July 22, 2021

Please see the responses to the comments received below.

LES SCHWAB TIRE CENTER CONSTRUCTION DOCUMENTS

7105 OLD MERIDIAN ROAD FALCON, COLORADO 80831

1 INITIAL GESC PLAN  
 C012

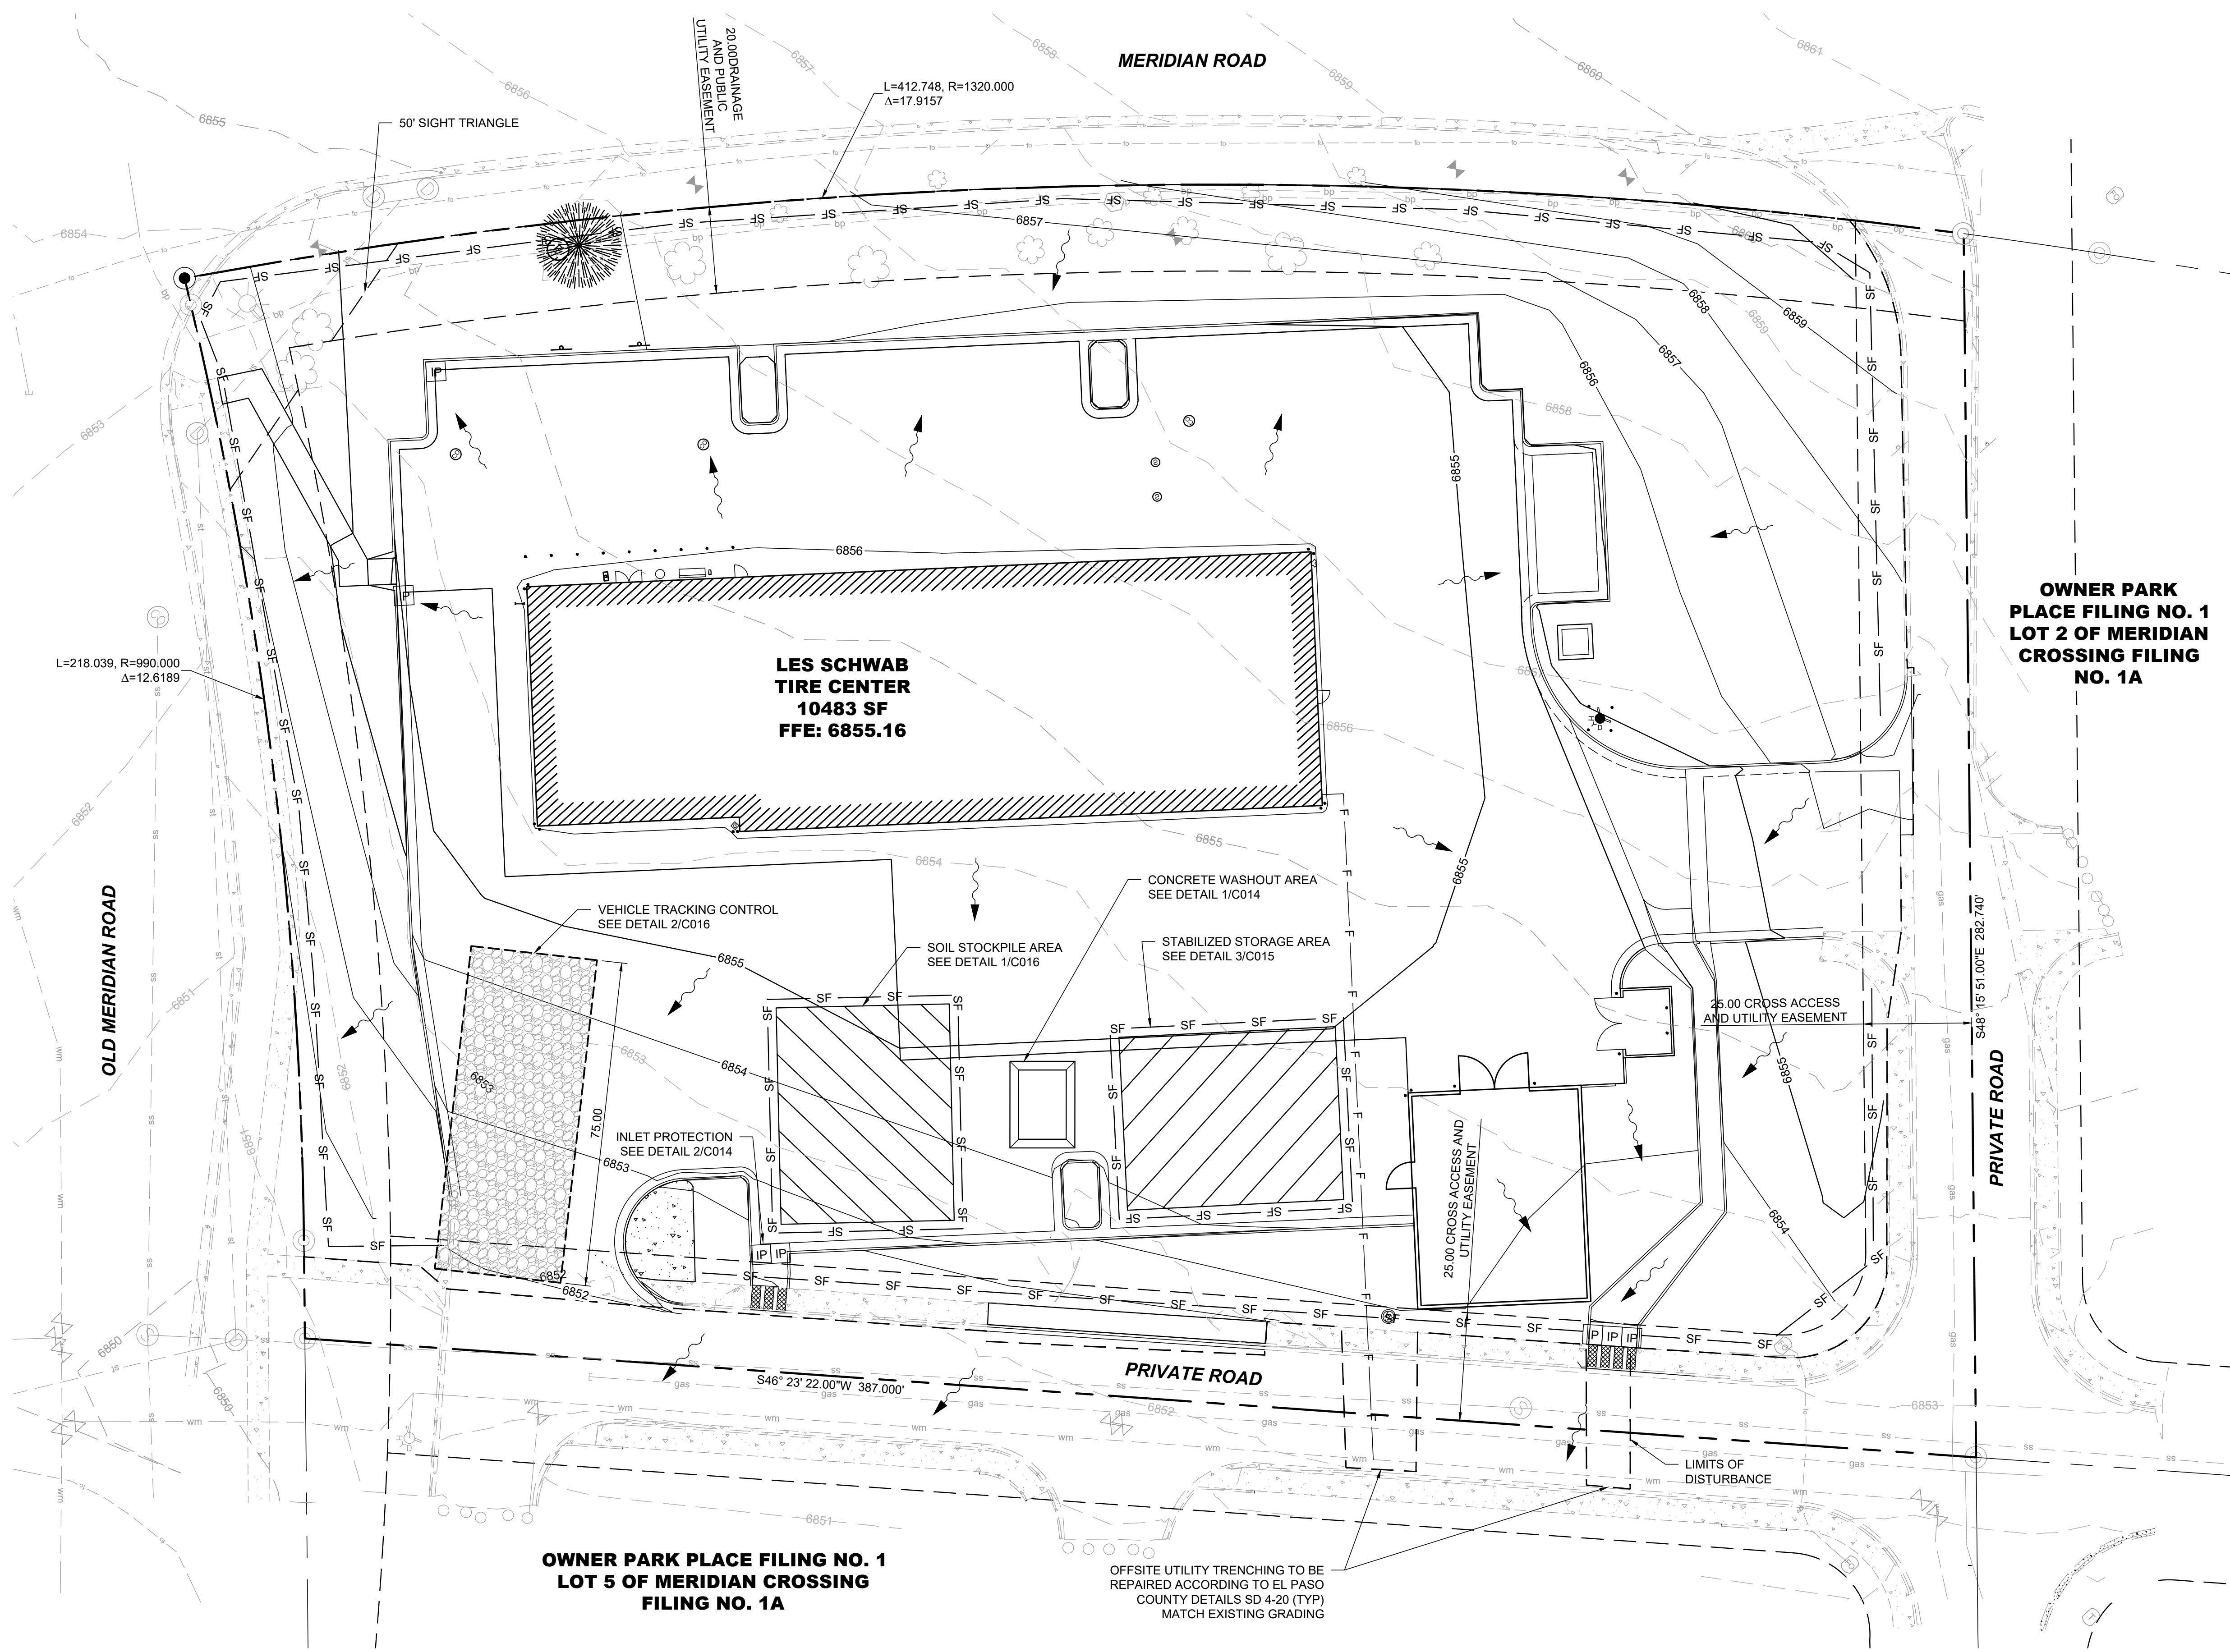
Item H and M. If "Limits of disturbance" and "construction boundary" are the same, change to "construction boundary/limits of disturbance" or otherwise show as separate linetypes for each on the legend and figure.

Increase to min 75ft per my comment on detail sheet below.

Label existing bollards to be removed per site dev plan.

Checklist Item "o" – clearly callout offsite grading. Note that the contractor may need to obtain and EPC "Work in the ROW" permit.

Response: Limits of disturbance label has been changed to read "LIMITS OF DISTURBANCE / CONSTRUCTION BOUNDARY"

Response: Vehicle tracking length increased to 75'

Response: Existing bollards to be removed callout added.

Response: Offsite grading for utility trenching noted to match existing grades.
